Critical Review of Hills of Gold Environmental Impact Statement - Soils Sections.

SoilFutures Consulting Pty Ltd January 2021

© SoilFutures Consulting Pty Ltd (2021). This report has been prepared specifically for the client, Hills of Gold Preservation Incorporated, a community interest group from surrounds of Nundle, who contracted SoilFutures Consulting Pty Ltd to critically review the EIS for the proposed Hills of Gold Wind Farm at Nundle. Neither this report nor its contents may be referred to or quoted in any statement, study, report, application, prospectus, loan, other agreement, or document, without the express approval of either the client or SoilFutures Consulting Pty Ltd.

Figure 2: Corrected LSC mapping with broad development footprint provided by SOMEVA

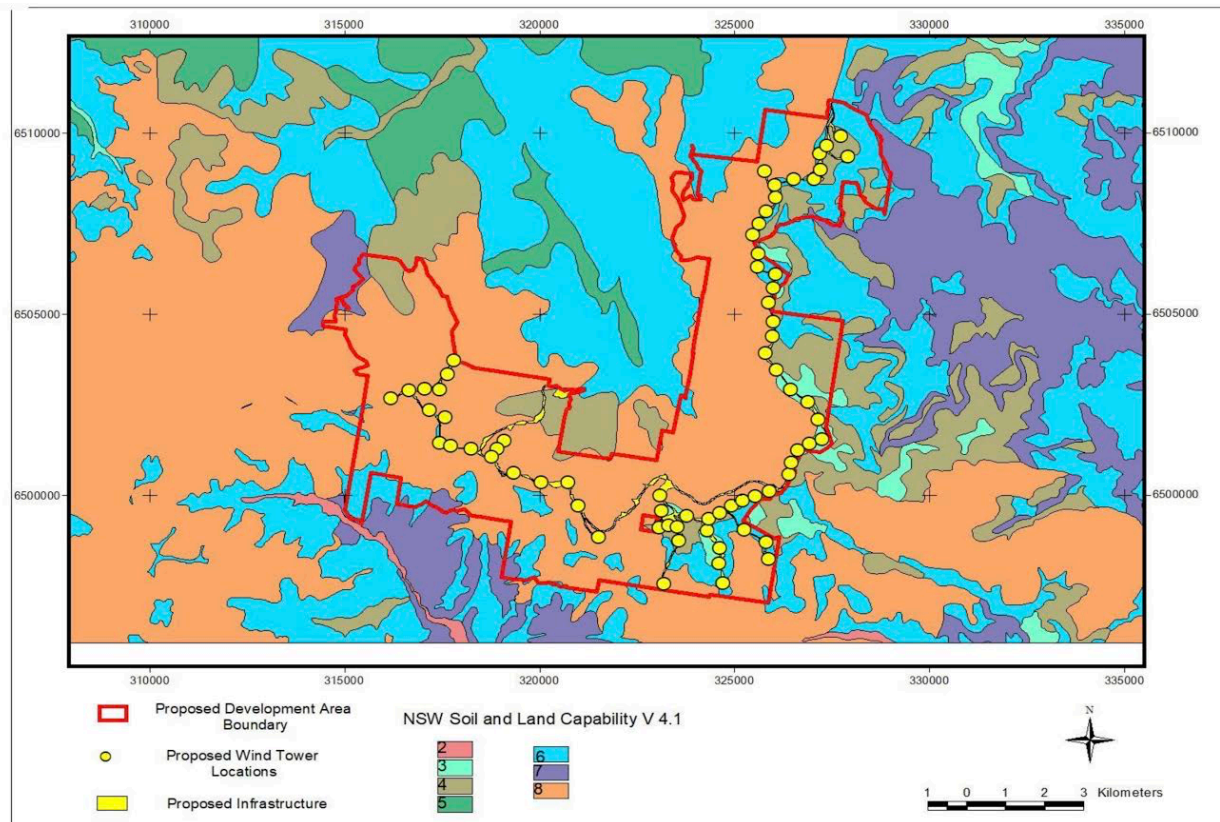
Please note that as a part of a review of the information in the EIS, a large error in LSC coding was found, and corrected in the State Data base following necessary NSW Government protocols. Digital data were provided for corrected LSC classes by DPIE to the reviewer. The new and current map is called *Land and Soil Capability Mapping for NSW*, V.4.1 Draft (DPIE, 2021, V4.1) This information is currently available on request and will be placed in ESspade and SEED in late January 2021. An accredited soil scientist would normally have noticed this discrepancy as part of the preparation of the EIS, especially if site visits had been undertaken.

The LSC maps presented in the EIS and the Appendix are incorrect as noted by this reviewer. A revision of the mapping gives more serious weight to erosion hazard recognition with respect to the area of proposed development. Figure 1 shows the map provided in the EIS for LSC. Figure 2 shows the corrected LSC data for the area.

As can be seen in the summary tables 2 – 4, 71% of the greater development area is Class 8 lands, 47% of proposed wind towers are in Class 8 lands and 54% of the development footprint is in Class 8 Lands. This means, at the scale of mapping, that around half of the proposed development is on mass movement dominated land with very high erosion risk. If these data had been correctly used by the consultant, then normally a field exercise to verify the soils and the slopes along the development footprint would have been made. Adjacent soil landscape mapping from McInnes provides erosion hazard and USLE factors. These could have at least been used as background data prior to a site visit.
